# **East Anglia ONE North and East Anglia TWO Offshore Windfarms**

## **Applicants' Responses to Examining Authority's Written Questions**

### **Volume 2 – 1.0 Overarching, general and cross-topic questions**

Applicants: East Anglia ONE North Limited and East Anglia TWO Limited  
Document Reference: ExA.WQ-1.D1.V1\_02  
SPR Reference: EA1N\_EA2-DWF-ENV-REP-IBR-001085 Rev 01

Drawing file: published-documents / EN010078-001408-6.2.29.33 EA2 ES Figure 29.33 Viewpoint 1 PRoW near Friston House (with National Grid GIS Substation).pdf

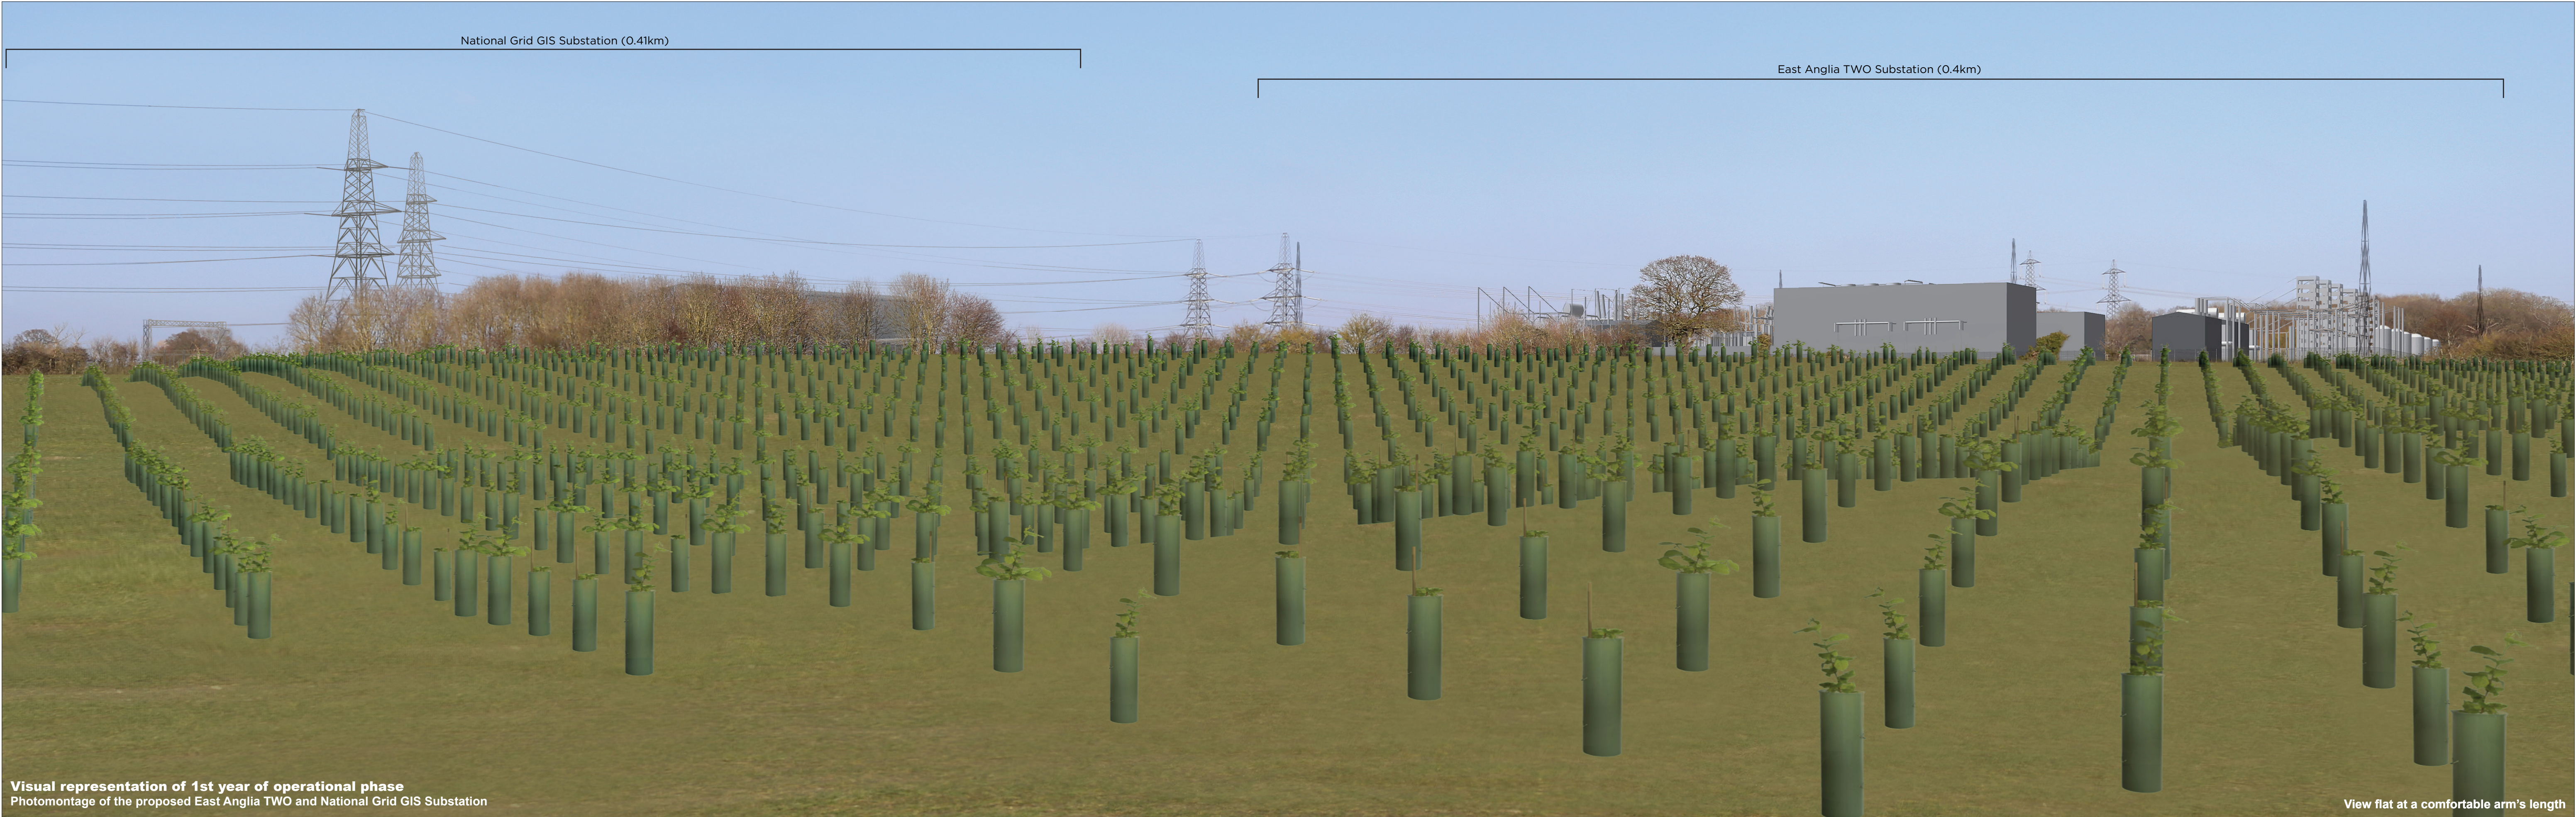
1.0.15	The Applicant	<p><b>Detailed substation design</b> Figure 29.33d shows a visual representation of the first year of operational phase for the proposals.</p> <p>a) What are the square stepped towers shown on the south east of the proposed EA1N and EA2</p>	<p>a) With reference to <b>Chapter 29 Landscape and Visual Impact Assessment</b> (APP-077) <b>Plate 29.1</b>, the 'square stepped towers' are Harmonic Filters (18m), of which there are six within each onshore substation.</p>

ExA. Question Ref.	Question addressed to	ExA. Question	Applicants' Response
		<p>substations and what is their function? (there are 12 shown in total)</p> <p>b) Provide an annotated plan of the proposed substation design to show the different elements of infrastructure/equipment that make up the individual elements of the substation</p> <p>c) Are these the same designs as other recently constructed substations, such as EA1, EA3 or the Galloper substations?</p>	<p>b) An annotated plan of the onshore substation layout is shown in the 3D model view in <b>Chapter 29 Landscape and Visual Impact Assessment</b> (APP-077) <b>Plate 29.1</b>. <b>Plate 29.1</b> identifies the different elements of infrastructure / equipment that make up the individual elements of the onshore substations, which are shown in the photomontage visualisations in <b>Figure 29.13</b> to <b>Figure 29.26</b> (APP-404 to 417). The substation layout is shown in plan view in <b>OLEMS</b> (APP-584) Figure 3-5.</p> <p>c) The substation layout shown was defined for the LVIA Rochdale envelope, as a worst-case informed by the maximum parameters of the required electrical infrastructure and was based on preliminary electrical design assumptions guided by the substation design from the East Anglia ONE project. The Galloper substation is not comparable to the Projects onshore substation as it serves a 353MW offshore windfarm (compared to 900MW and 800MW at the point of connection for the East Anglia TWO and East Anglia ONE North respectively) and received power at 132kV (compared to the Projects which receive power at 275kV). The East Anglia THREE project utilises HVDC technology due to its output (1,400MW) and therefore will require a converter station rather than an onshore substation.</p> <p>The substation most similar to the Projects is considered to be the East Anglia ONE substation which has been recently commissioned by East Anglia ONE Limited.</p>
